Our ref: H8040/6.0  
Your Ref: 2019-93658 & 2021/70/94488E

**Re Application for discharge of details reserved by condition  
ERECTION OF 122 DWELLINGS, LANDSCAPING AND ASSOCIATED INFRASTRUCTURE  
LAND AT, WHITECHAPEL ROAD, CLECKHEATON**

**Conditions 8, 9 & 10**

DRAWING NO: **H8040-0009 DETAILS - ENGINEERING\_AFU...S38 PROW LEVELS PLAN SHEET 4 OF 4** REV: **P06**

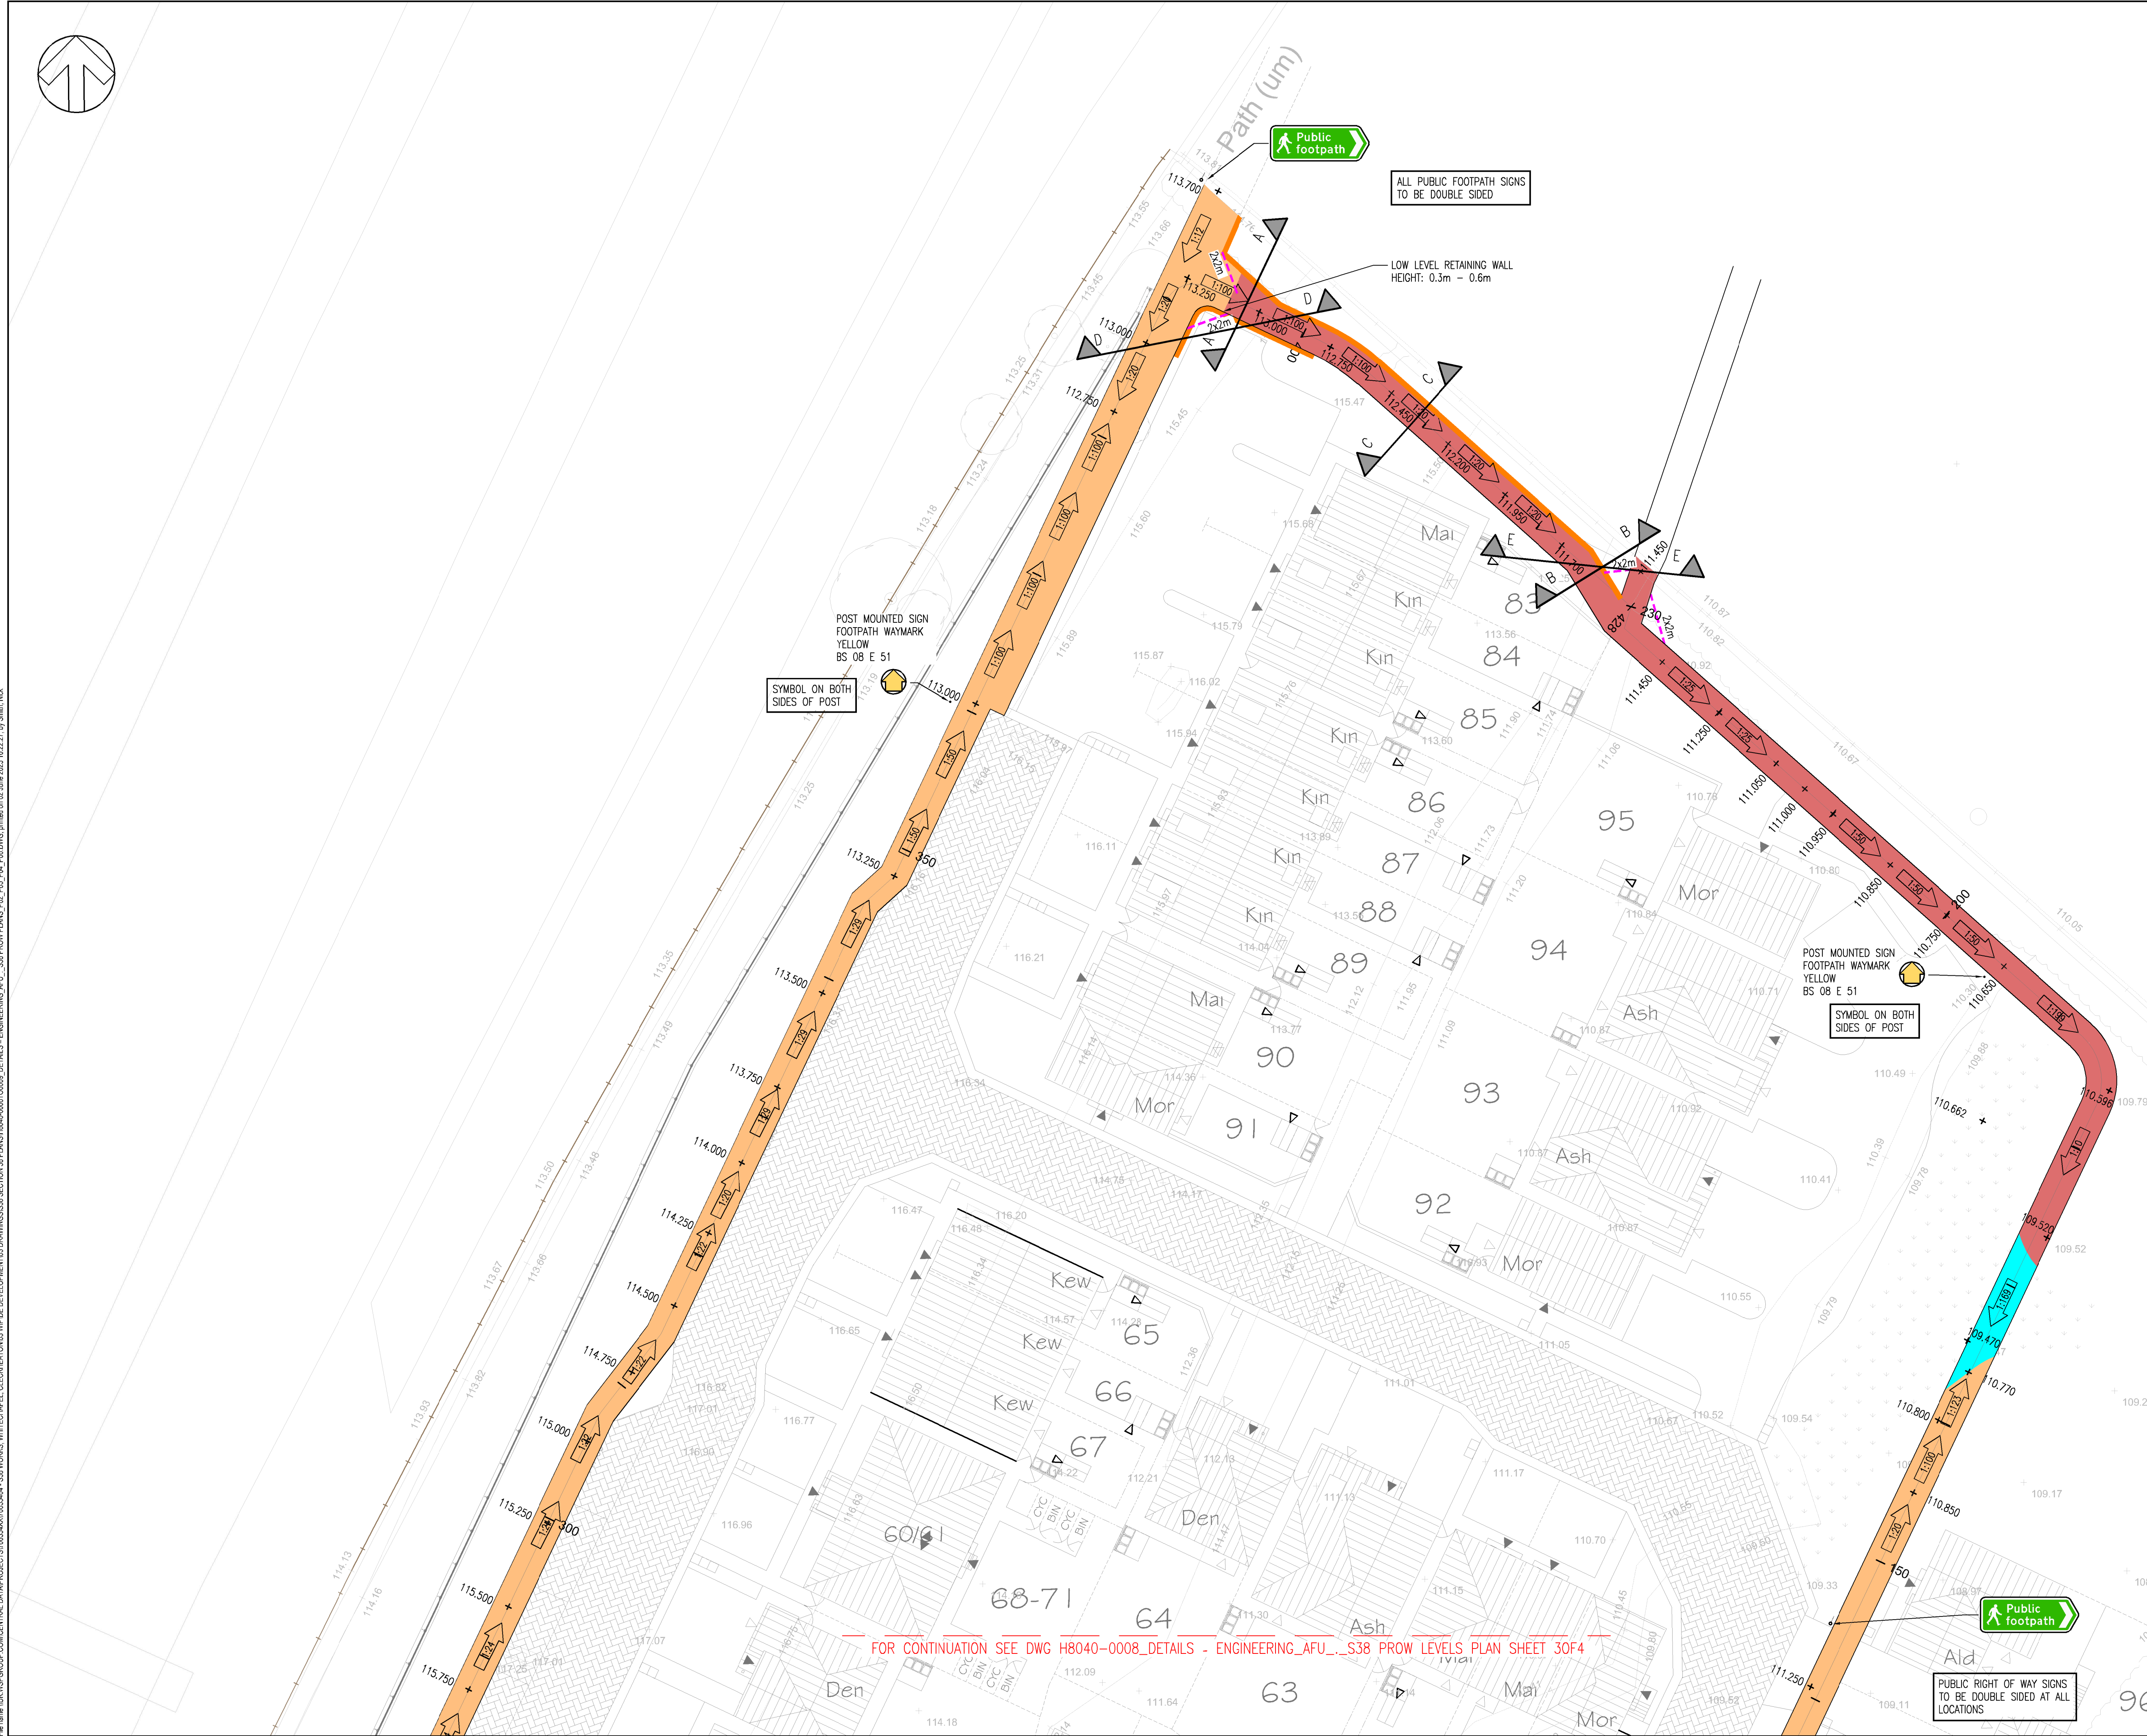
1. Safety of PROW , proving visibility splays work at keen locations discussed , e.g.
2. Bottom of ramp, North PROW link (Order plan C-G-K)
3. Tidied area to the north where some retaining walls, plot 83 side having been removed making for a more visible , direct route to the PROW between points (Order plan C-G-K)
4. Tactile crossing points identified near Plot 34 & 111 at the request of the PROW officer
5. 2m wide path splaying to 2.45m at Vis plays a North PROW Link ((Order plan C-G-K)
